Environmental Health Division
1675 W. Garden of the Gods Road
Suite 2044
Colorado Springs, CO 80907
(719) 578-3199 *phone*
(719) 578-3188 *fax*
www.elpasocountyhealth.org

Barbarick Transfer Station, 8812 Cliff Allan Pt., AL-23-10

Please accept the following comments from El Paso County Public Health regarding special use project referenced above:

SITE PLAN EXHIBIT - AL2310

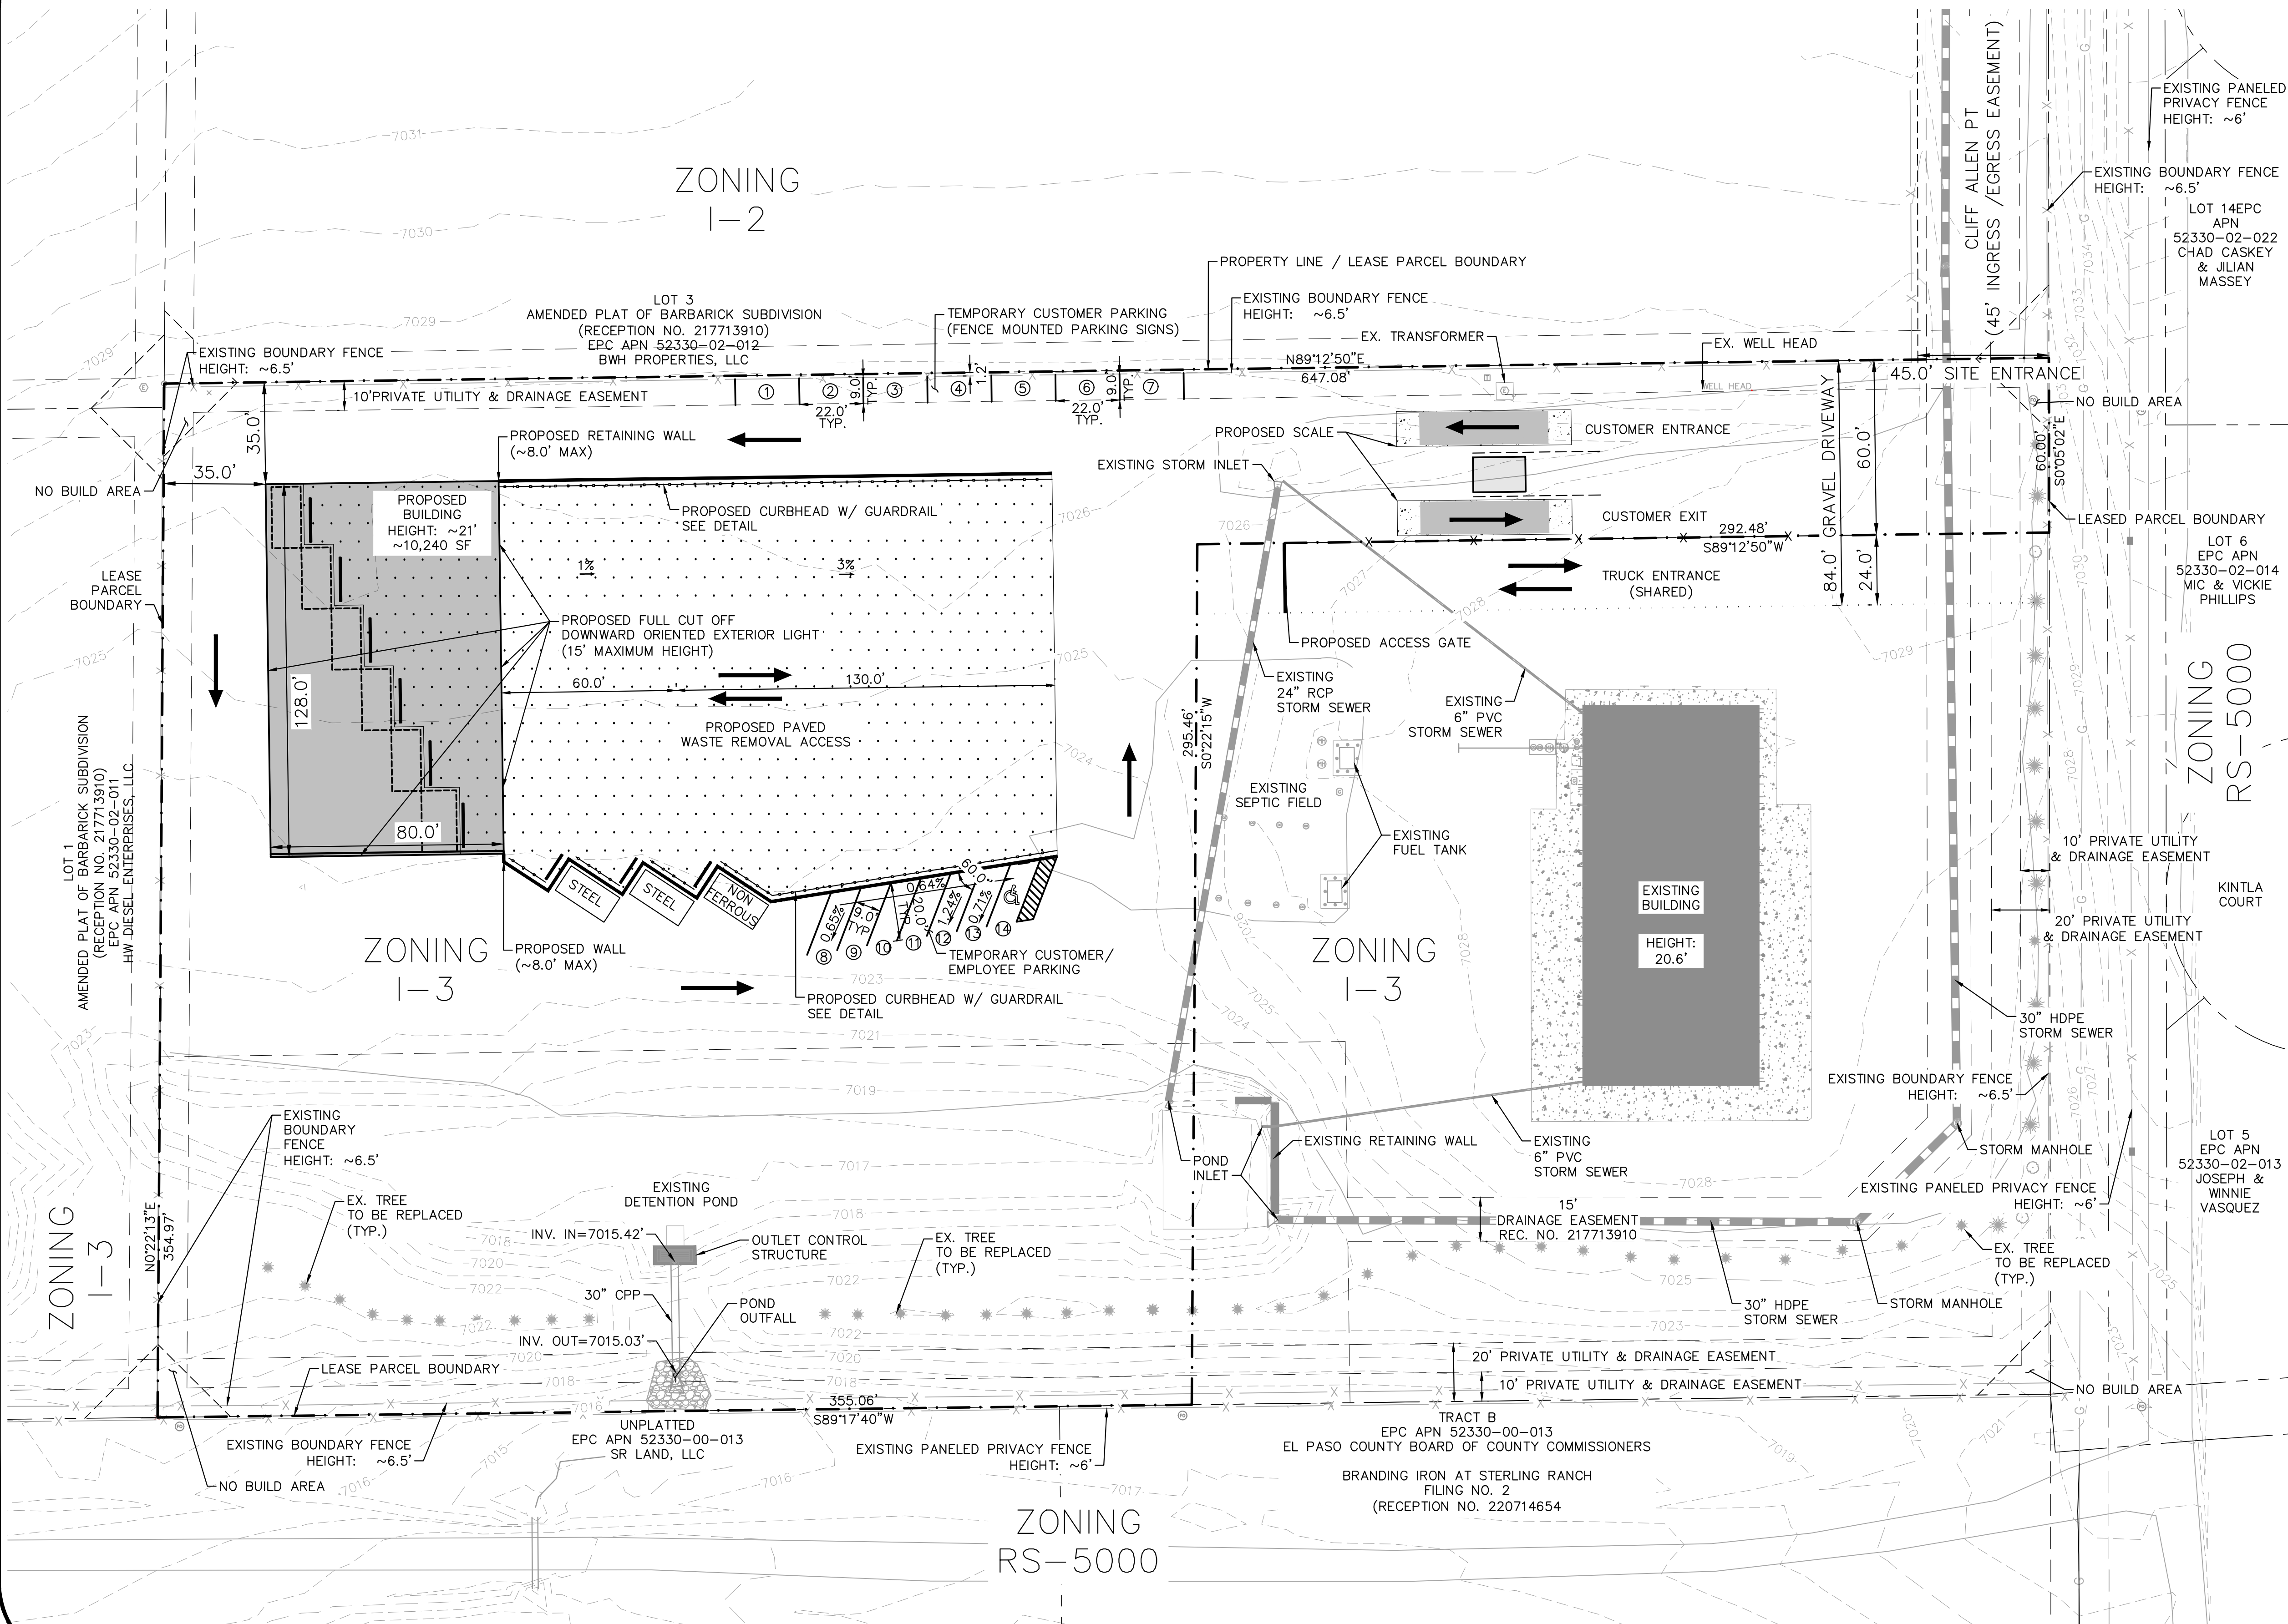
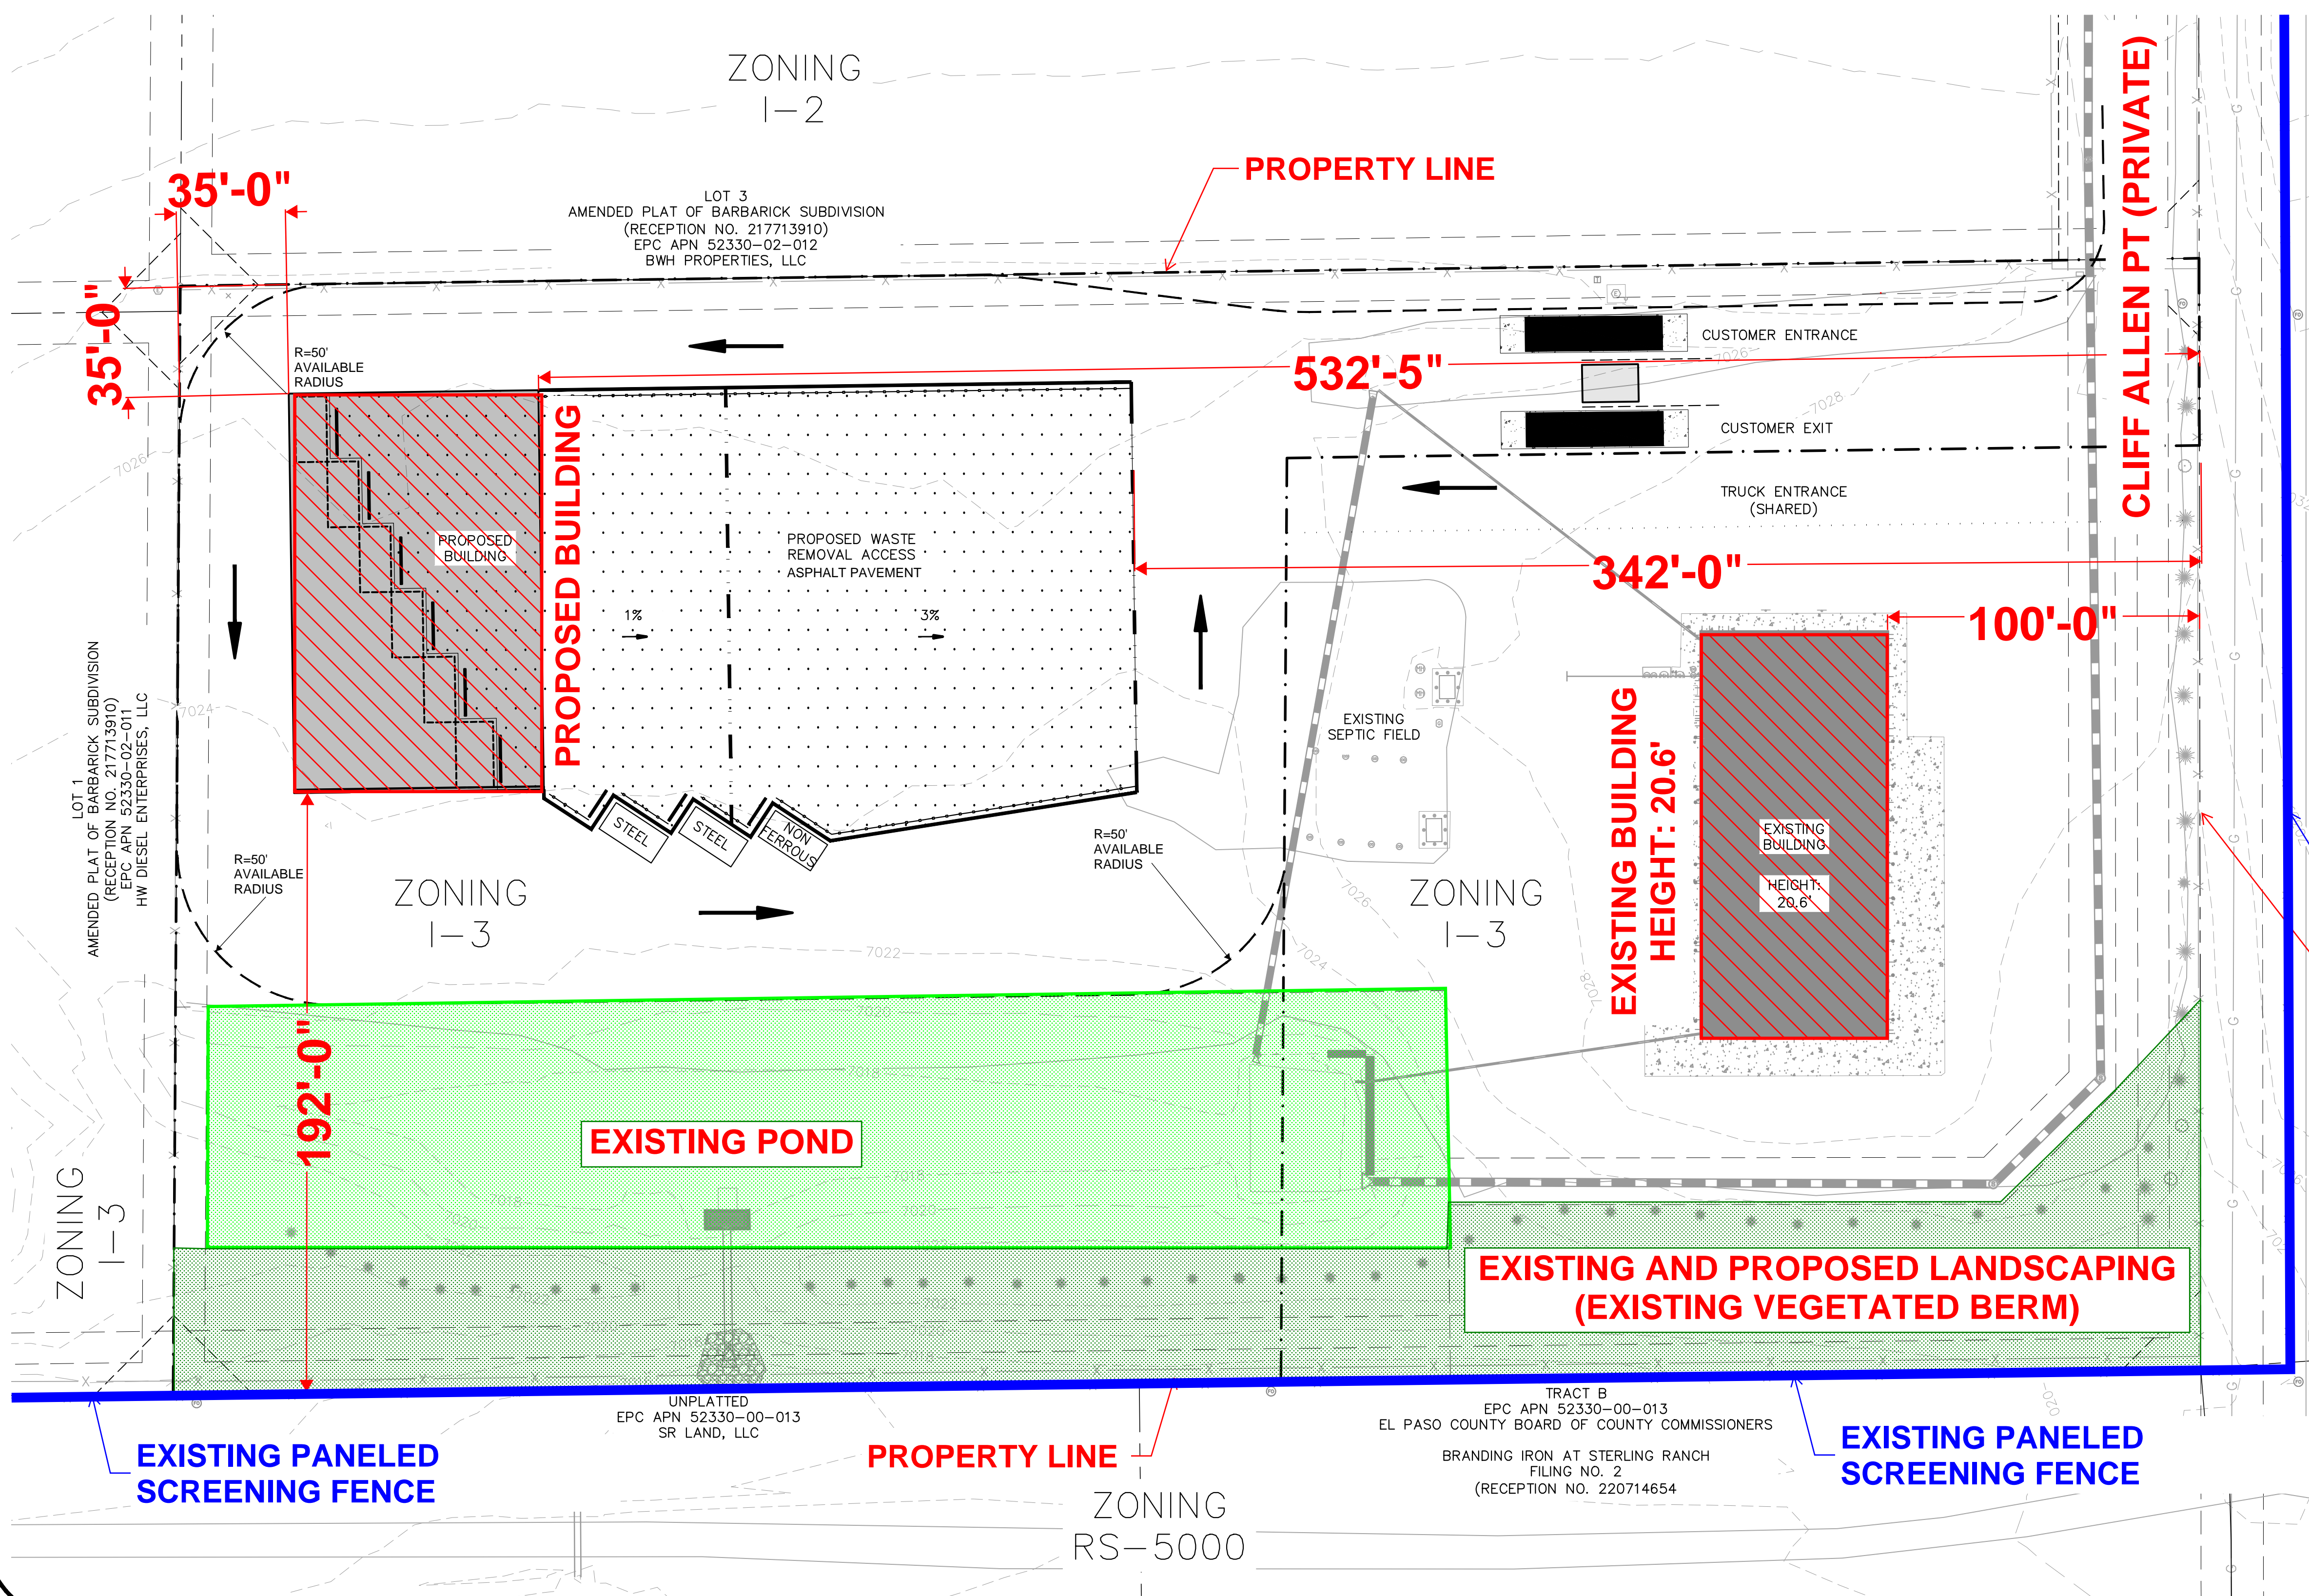
- The water quality basin must have mosquito control responsibilities included as a part of the construction design and maintenance plan to help control mosquito breeding habitat and minimize the potential for West Nile Virus.

DESIGN CRITERIA FOR PROPOSED COMMERCIAL BUILDING
COMMERCIAL DEVELOPMENT - TABLE 6 2
OFFICE BUILDING PER EMPLOYEE PER EIGHT HOUR SHIFT: 15 GPD/PP
TOTAL DESIGN PEOPLE: 8
WASH FIXTURE PER BAY (3): 50 GPD PER FIXTURE
DAILY FLOW: 270 GALLONS

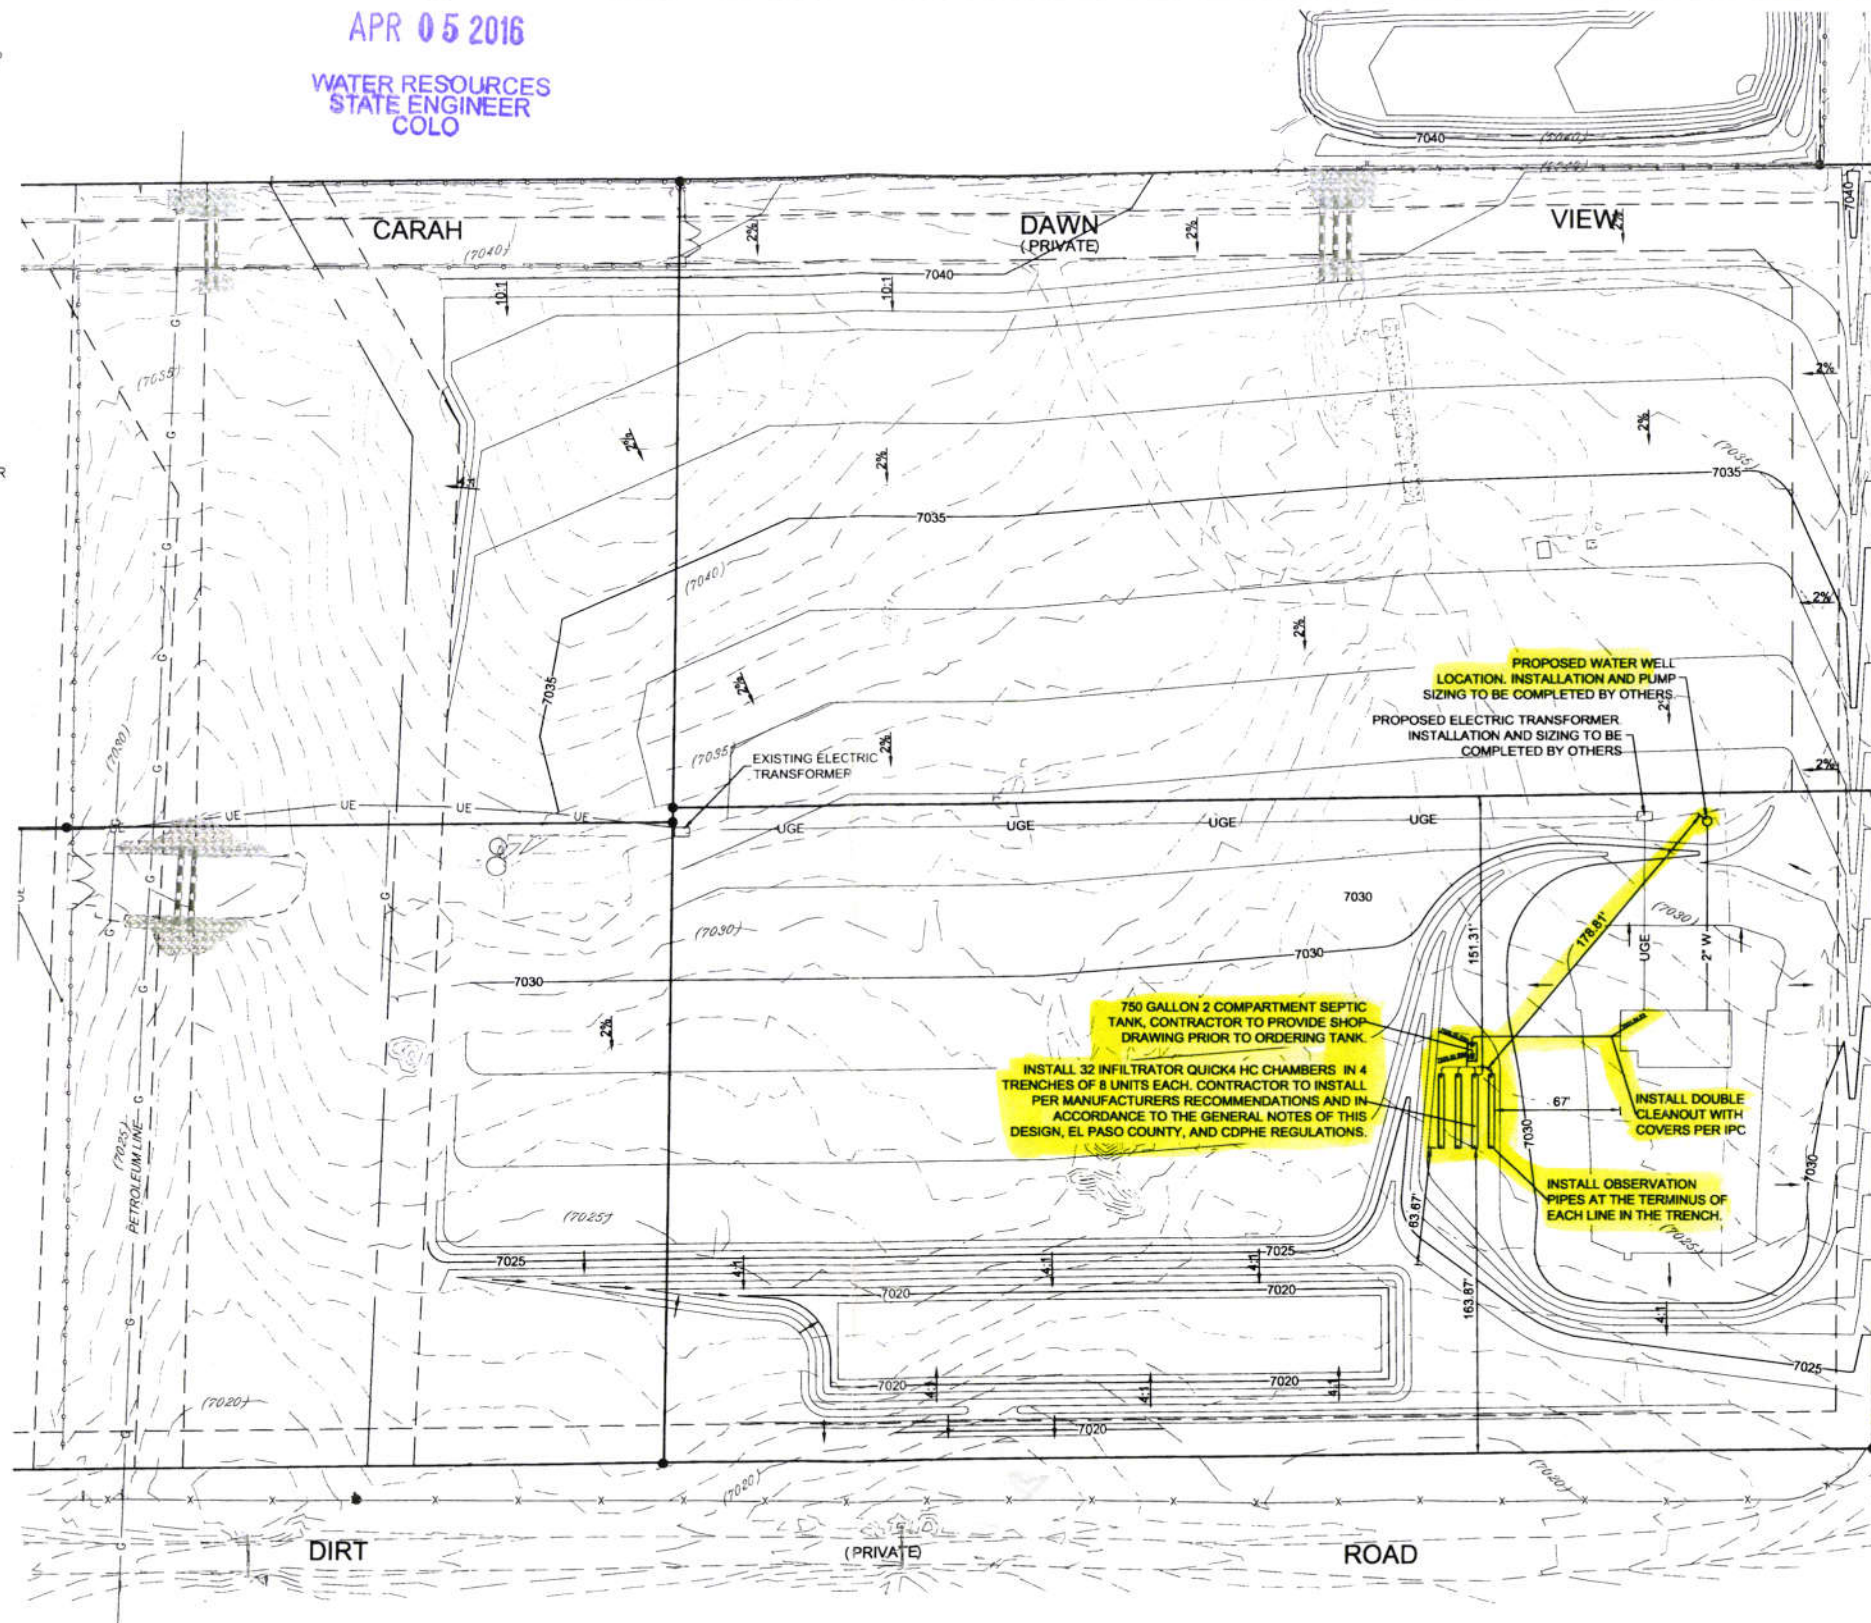
- A record of 1 permitted professional engineer designed Onsite Wastewater Treatment System (OWTS) issued in 2016 is on file for the existing structure on the site. The OWTS component locations must be located to assure the components of the OWTS are protected from vehicular traffic and other means of compaction.

- The OWTS must be adequate in size for the anticipated increase in demand for the proposed transfer station employees. An OWTS design engineer must provide written verification to El Paso County Public Health (EPCPH) of their review findings.

- Adequate area must be reserved on the property for a secondary site for the possibility of a repair, addition, or replacement of the existing soil treatment area.
